Planning Services Sign Permit Review Form

Date of Submittal	Application Number	Applicant	Landowner
3/31/2022	SIGN2203-0007	Grand Entrance Group	LGI Homes NC INC

Contact Person	Debbie Cattano	Contact Number	919-355-2507
Sign Location	2 locations – 1 at the intersection of NC 210 and Warwick drive, and 1 at the intersection of NC 210 and Royal Meadow Dr.	PIN Number	0662-56-1185.000 & 0662-07-1679.000

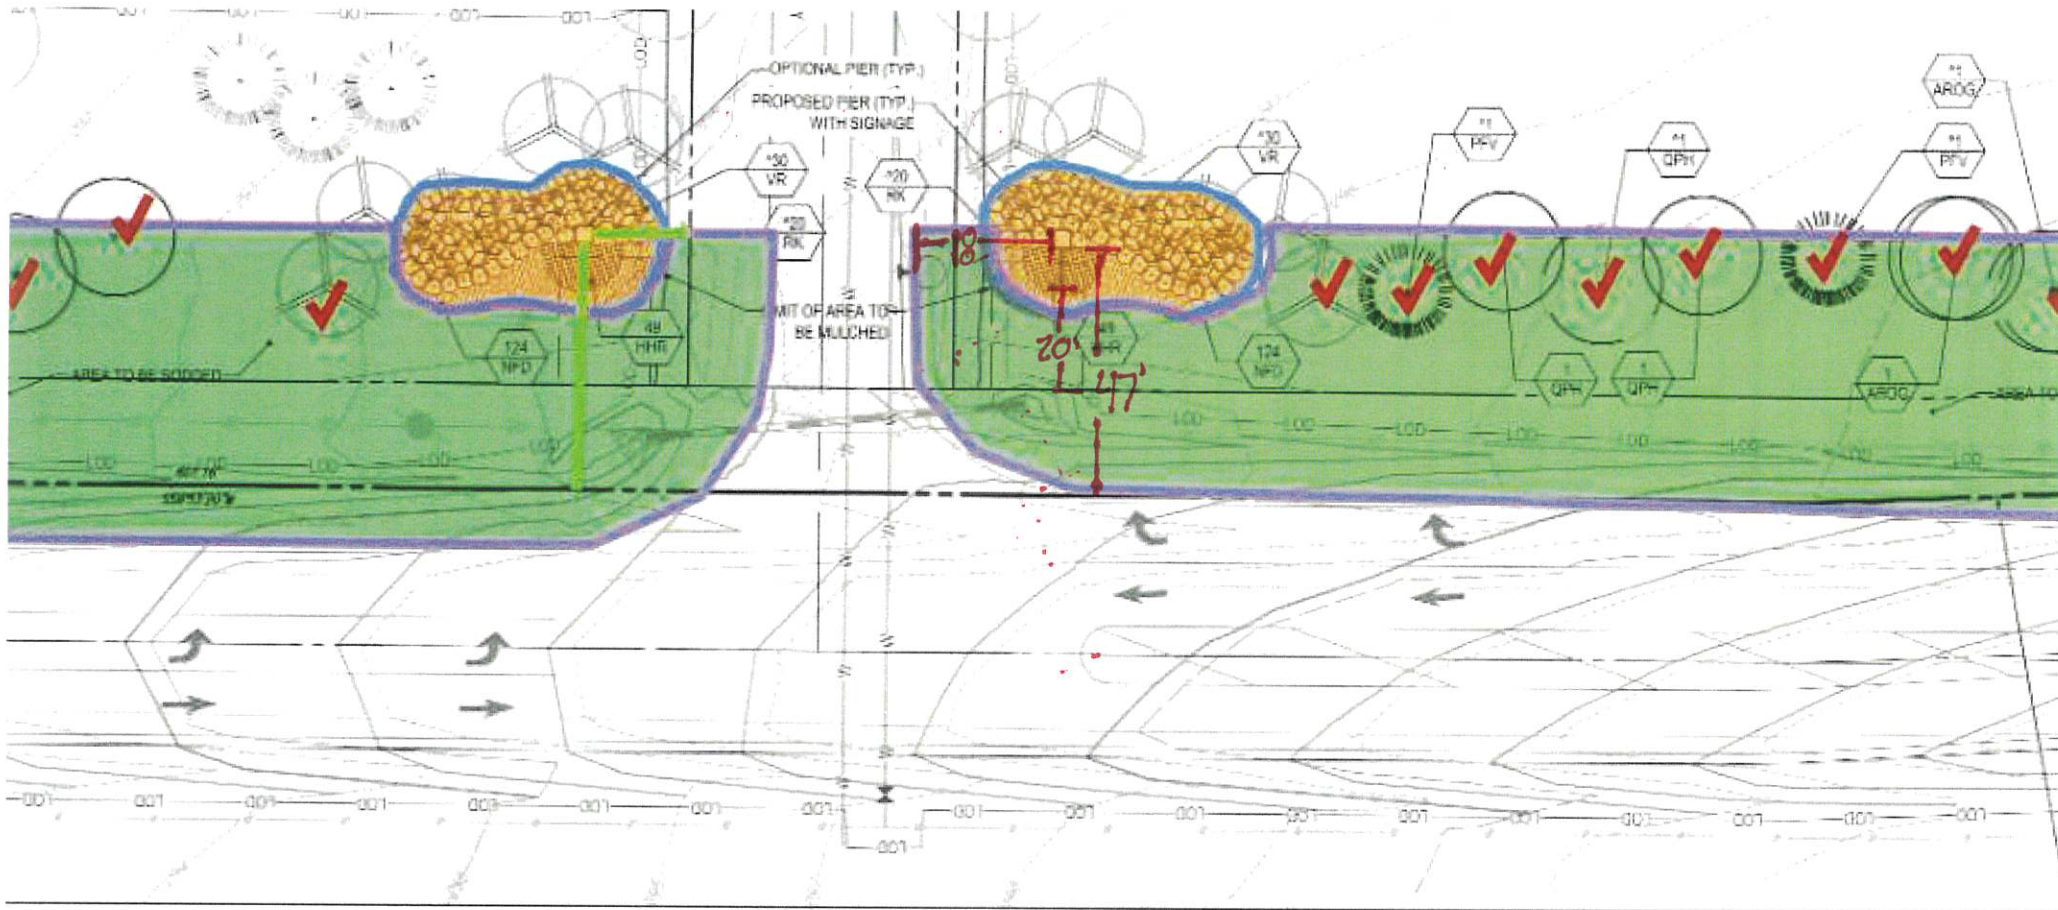
Comments	More Information required. <ol style="list-style-type: none"> 1. Please submit a site plan that illustrates the location of the signs and the distance between the signs and the ROW and any property lines. A minimum 20' is required from each right-of-way line or property line in both directions if at an intersection. 2. Please advise if signs are one sided.
----------	---
